**GABRIEL MC HUGH & ASSOCIATES --, PSDP&PSCS certifier
STRUCTURAL DESIGN AND CALCULATIONS
SURVEYING SERVICES
PLANNING APPLICATIONS
VALUATION AND CERTIFICATION SERVICES**

RE the wind farm project known as the Laurclavagh Wind Farm Project.

I received a request from a local family to carry out a survey on the area where the L61641 connects to the N83 (which is the junction proposed to be used for all construction access to the proposed work site for the Wind Farm project, and I was also requested to review the traffic management plan proposed by the applicant.

PROJECT TITLE:			
Laurclavagh Renewable Energy Development, Co. Galway			
DRAWING TITLE:			
Temporary Access Road N83 / L-61461			
PROJECT No.:	DRAWING No.:	SCALE:	
210627	210626 - 38	1:1,000 @ A3	
DRAWN BY:	CHECKED BY:	DATE:	REVISION.:
JOB	TH	13.03.2024	P01

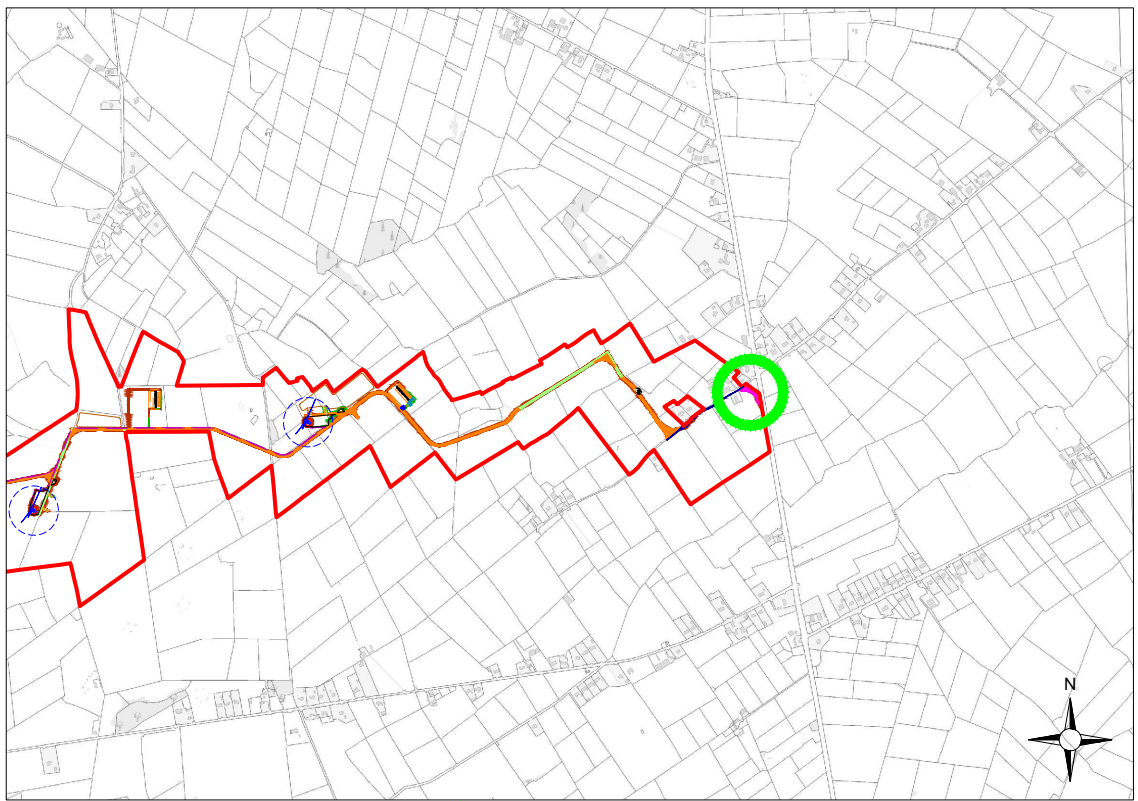
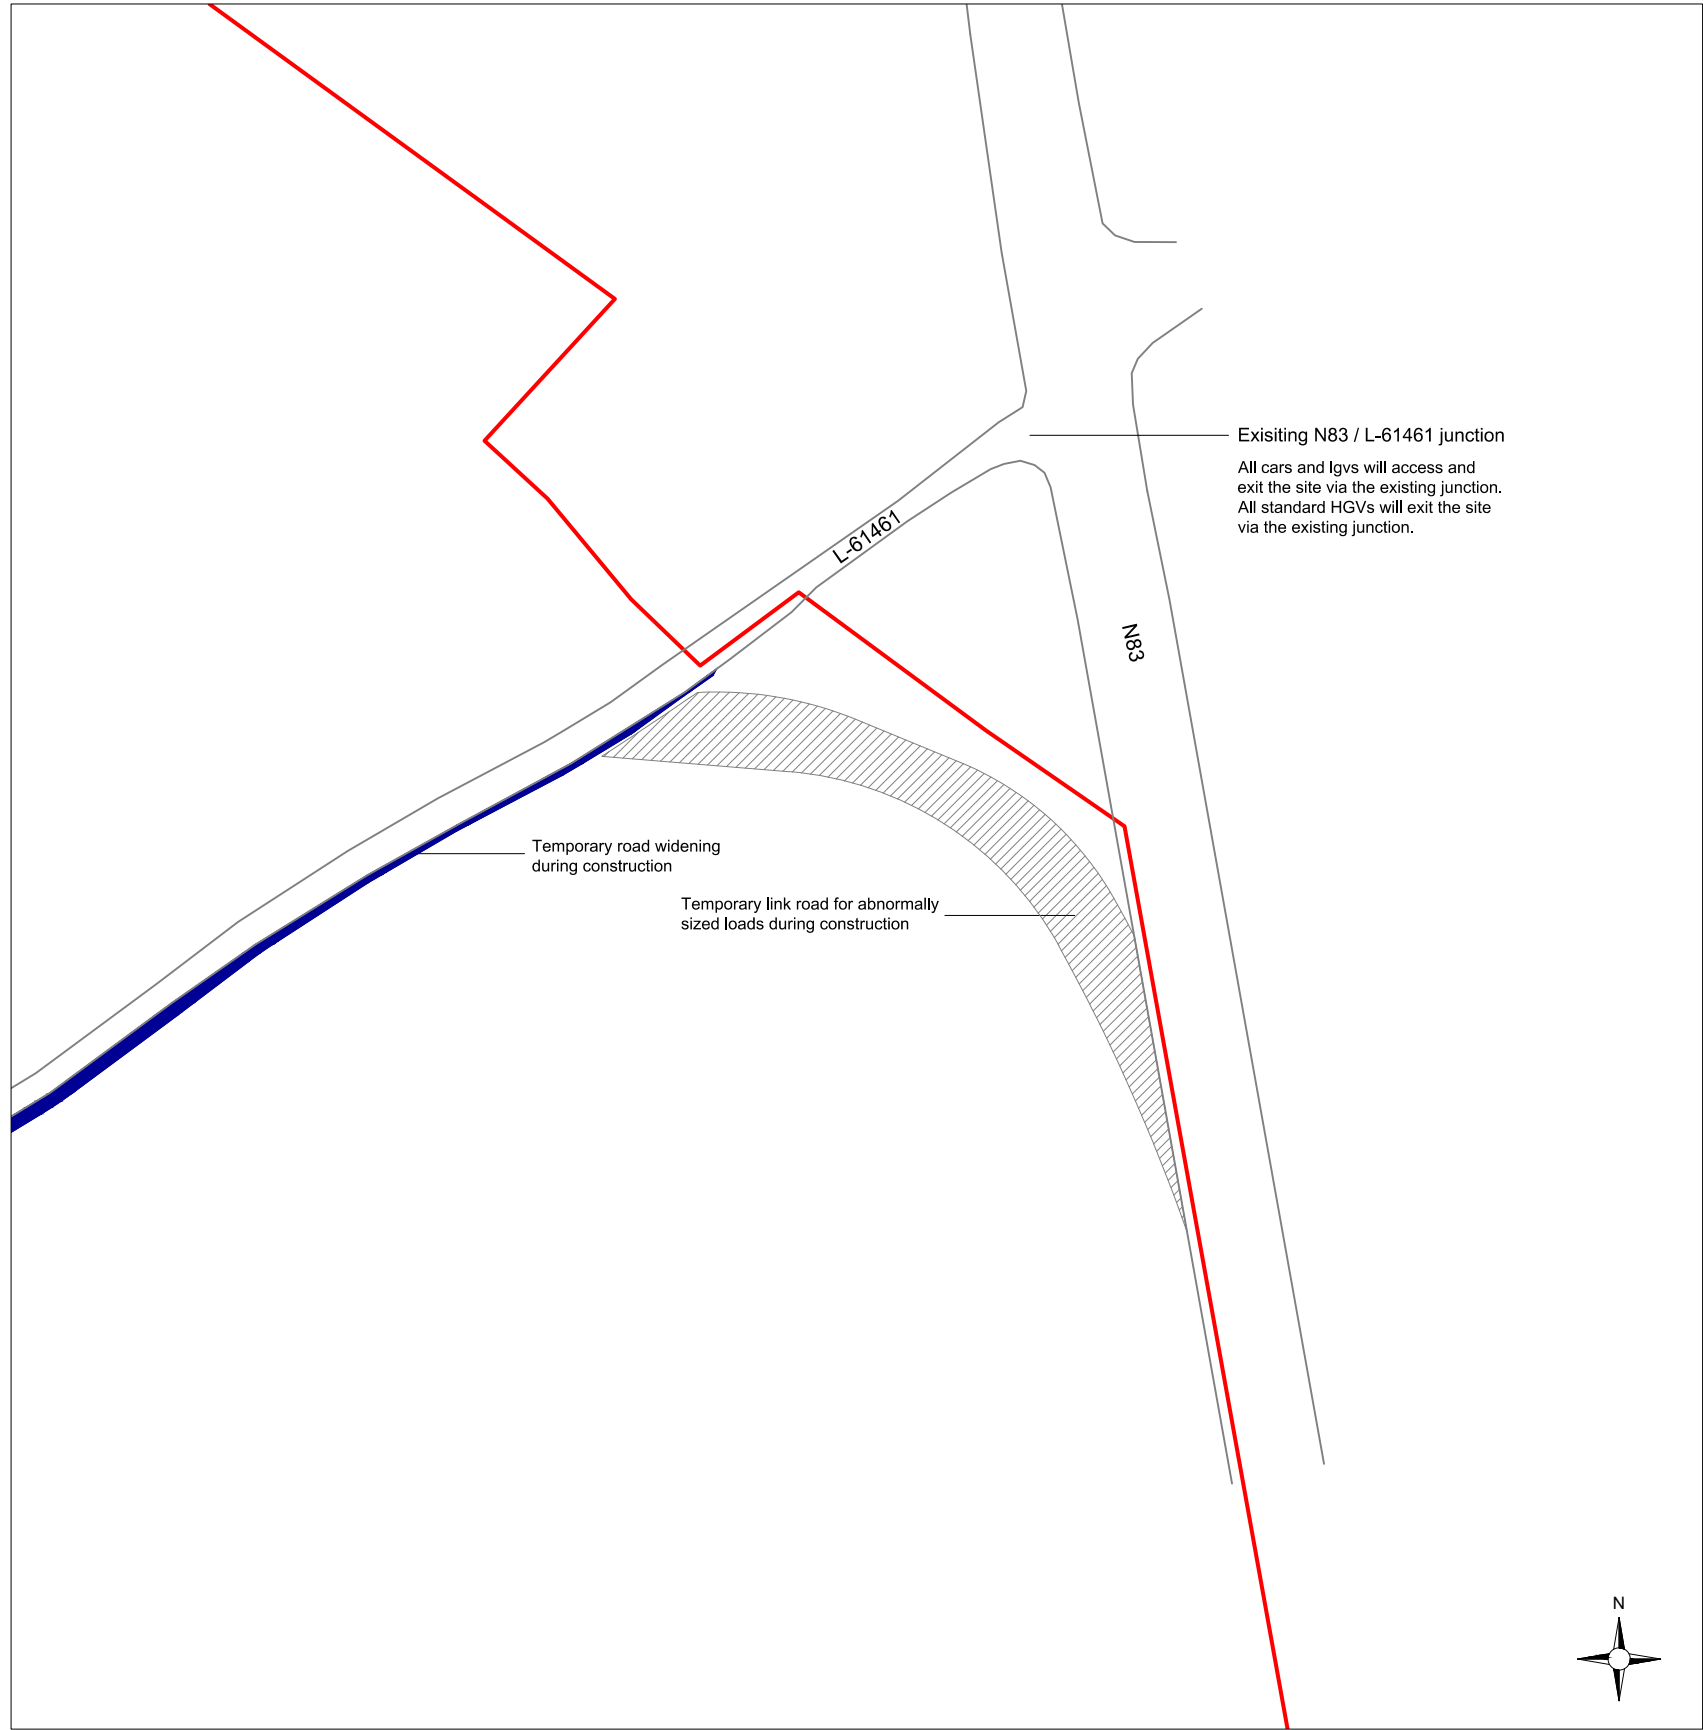
- 1) The L61641 Tarred area varies in width from 2.8m to 4.0 m over the area include on the drawing. Allowing for the width of a HGV being 2.5m (plus the Mirrors) this leaves not even sufficient room for a person to walk beside the HGV,

- 2) There is no location along the L61641 that two vehicles of any kind can meet and pass by without driving on to private property. This will obviously create serious issues for the local residents and their families.

- 3) Within the relevant sight line there are multiple active entrances and exits from private house, farm yards, agricultural field entrances, the proposed temp slip road approx. 50 entrances in Total. also very important from a health and safety point the school bus pick up point is directly at the junction 4 busses per day with multiple school children walking to this collection and drop off point. With a commuter bus also stopping at the junction approx. 25 times per day also a health and safety issue.

- 4) The HGV manoeuvres to enter and exit between the N83 and the L61641 will not work as proposed see attached drawing for detail around why these manoeuvres will not work as proposed. Not sufficient turning space and crossing over on to the second lane of traffic on the N83.

PROJECT TITLE:			
Laurclavagh Renewable Energy Development, Co. Galway			
DRAWING TITLE:			
Proposed access junction off the L-61461			
PROJECT No.:	DRAWING No.:	SCALE:	
210627	210626 - 39	1:1,000 @ A3	
DRAWN BY:	CHECKED BY:	DATE:	REVISION.:
JOB	TH	13.03.2024	P01

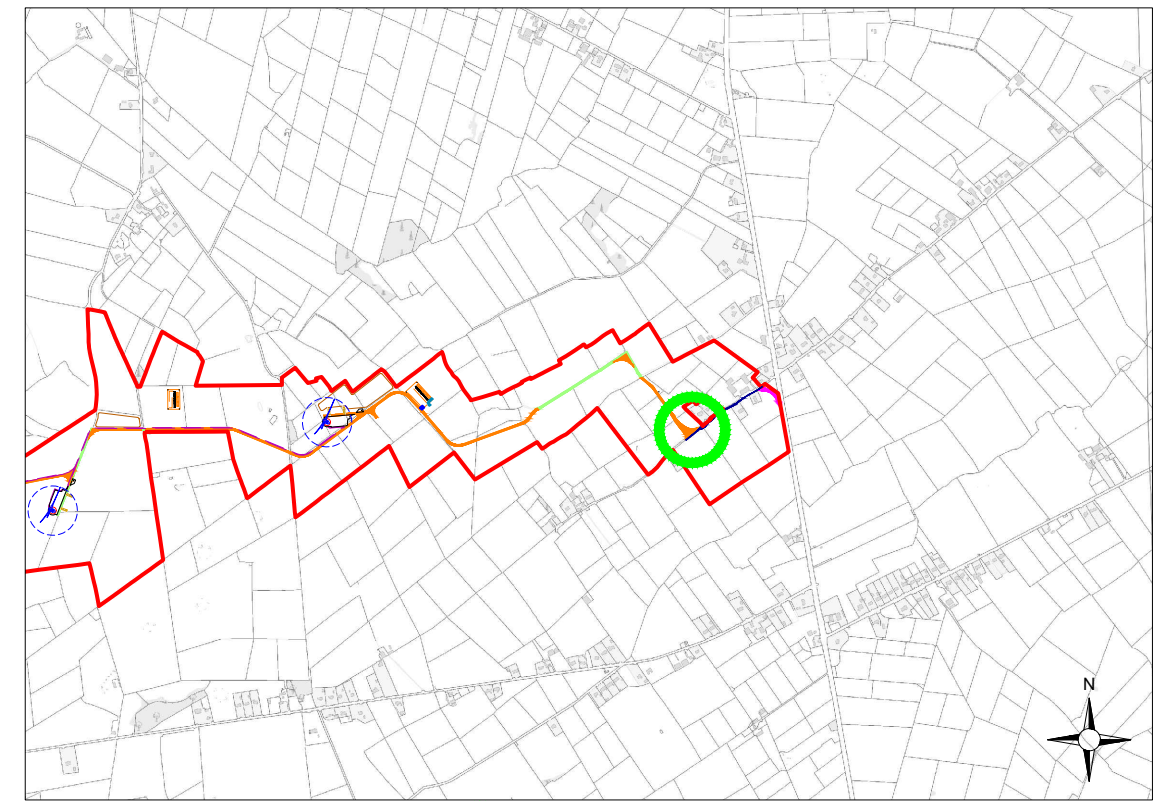
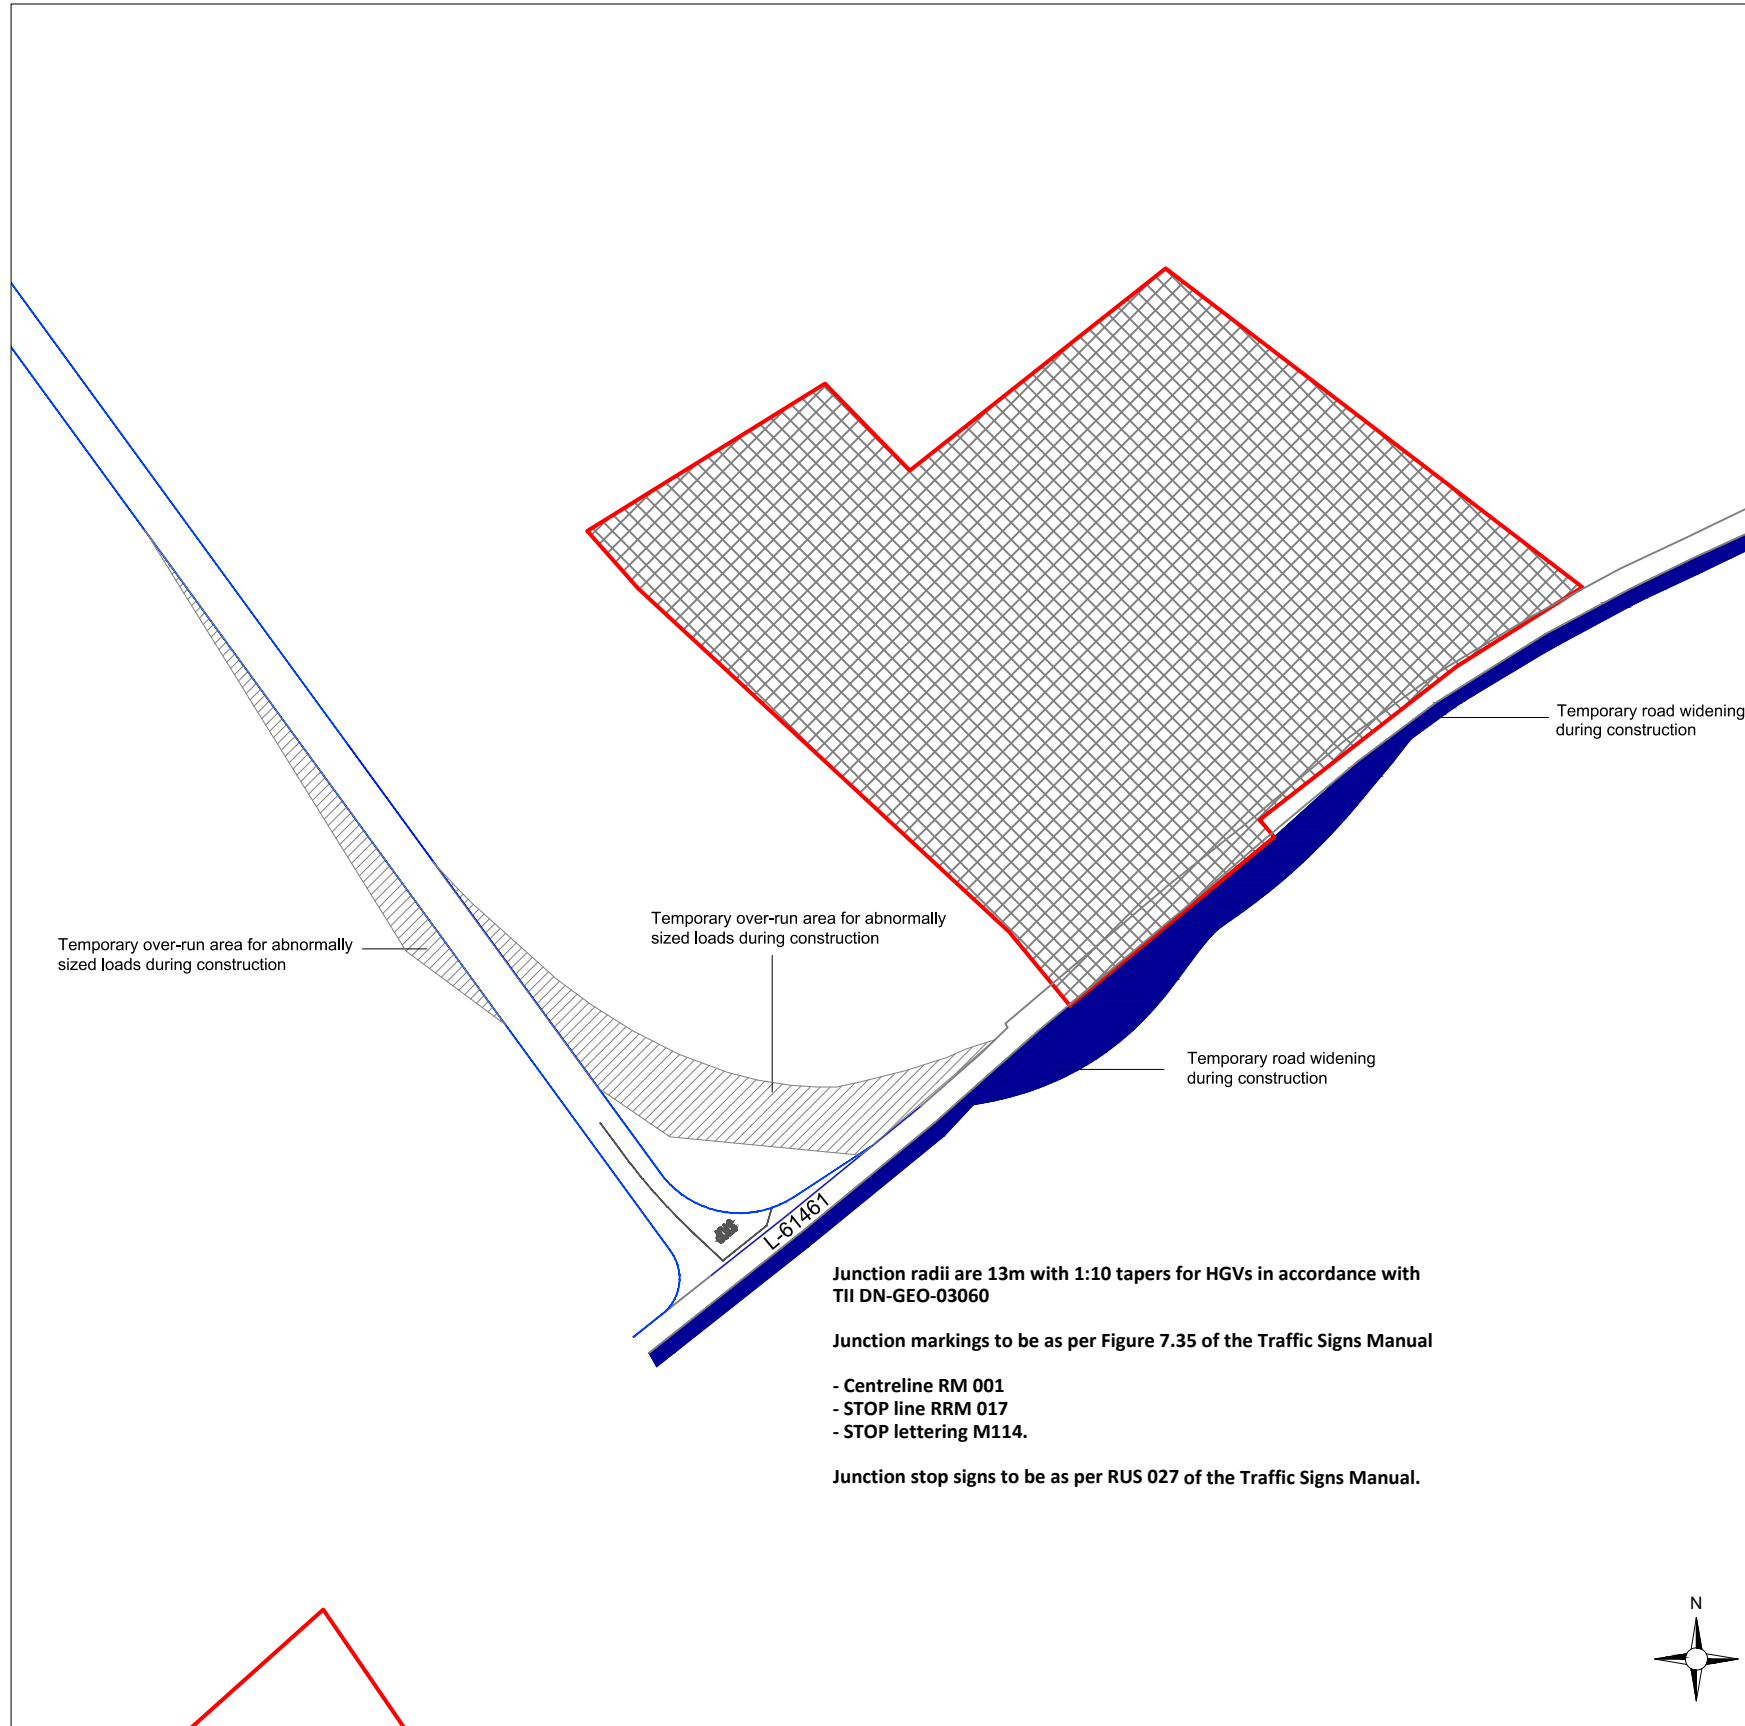
Note- the local land owners has assured me that no consent has been given by them to widen this road at any time, despite the fact that the planning application has proposed widening this road without landowners consent.

- 5) An additional large element of the works that will have major impact on the L61641 and its users that has not been addressed is the excavation of the entire length of the road to allow the laying of the power cables that are proposed to be laid under entire length of the road.
